Our ref: DOC20/322928

Response to Submission comments for Mixed Use Development at 75-85 Harrington Street, The Rocks (SSD 7037 Mod 3)

Thank you for your referral dated 27 April 2020, inviting comments from the Heritage Council of NSW on the above State Significant Development (SSD) Response to Submissions.

title
Plans
Level H1 - C2 Floor Plan

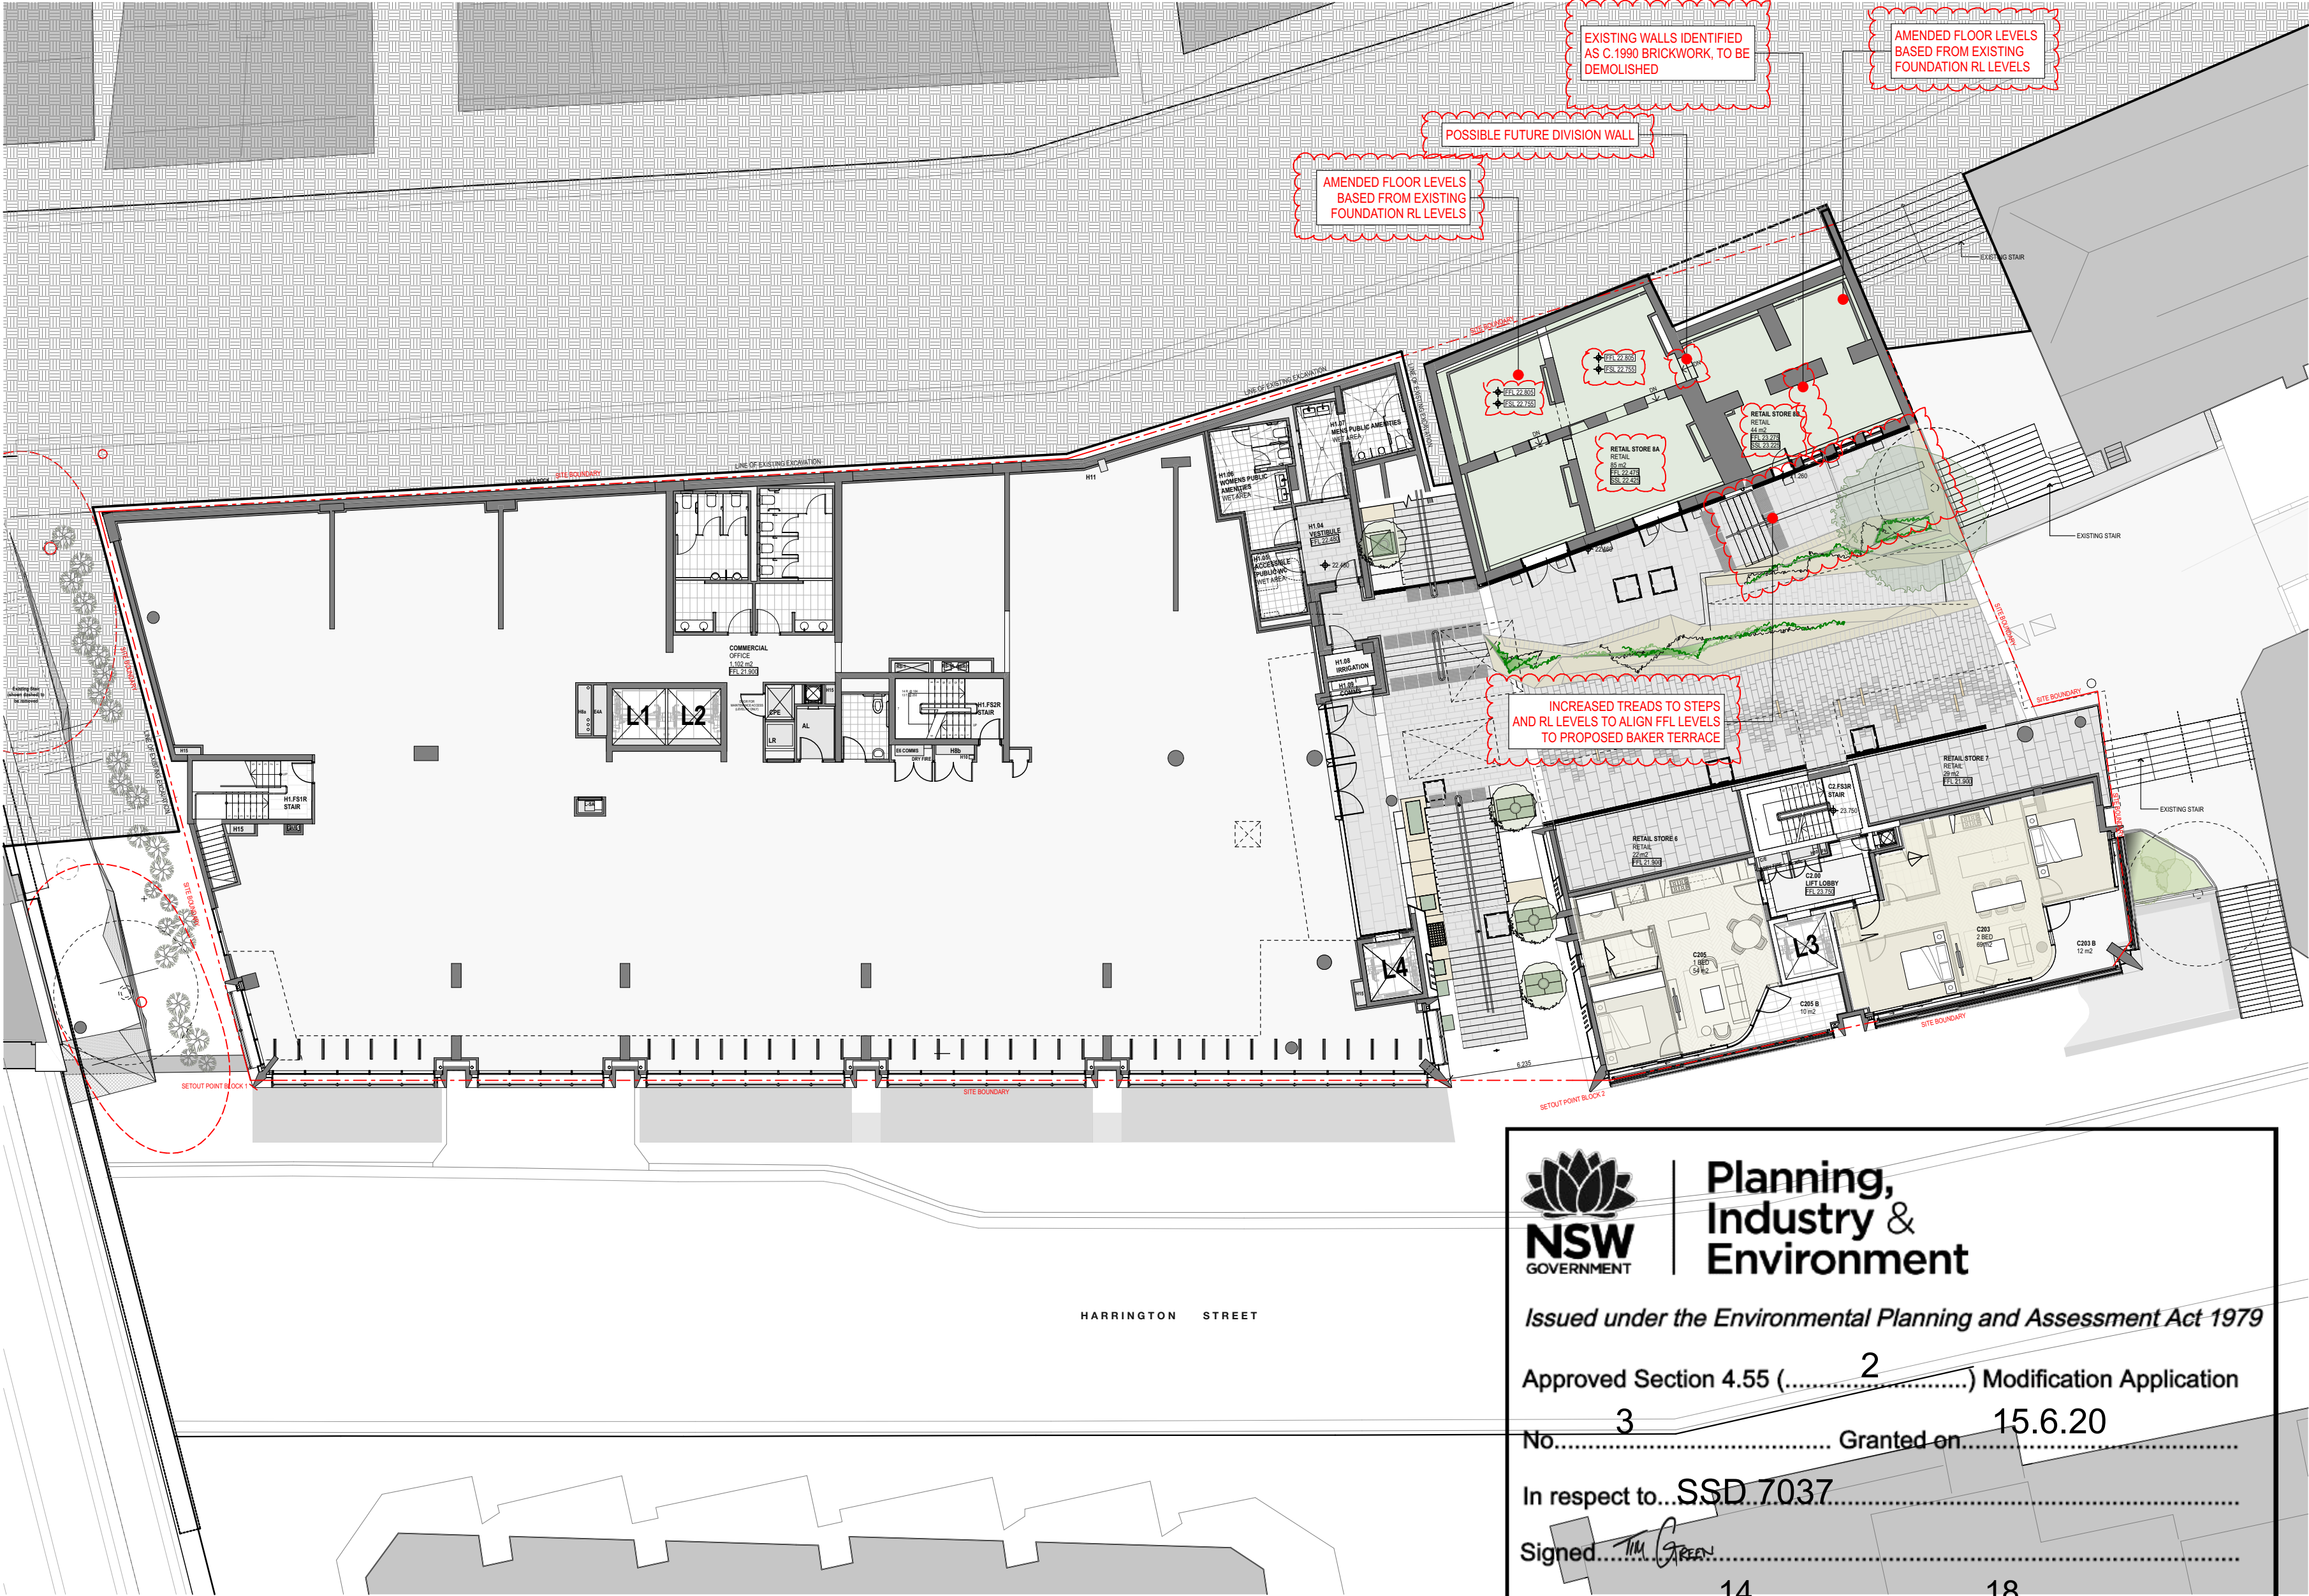
It is considered that although removal of later walls (1990s infill) is acceptable, the original room layout of the terraces must be interpreted in the replacement layout. The applicant should be asked to demonstrate how this has been achieved in the modified design. No objection is raised to other changes provided they do not adversely impact on significant fabric.
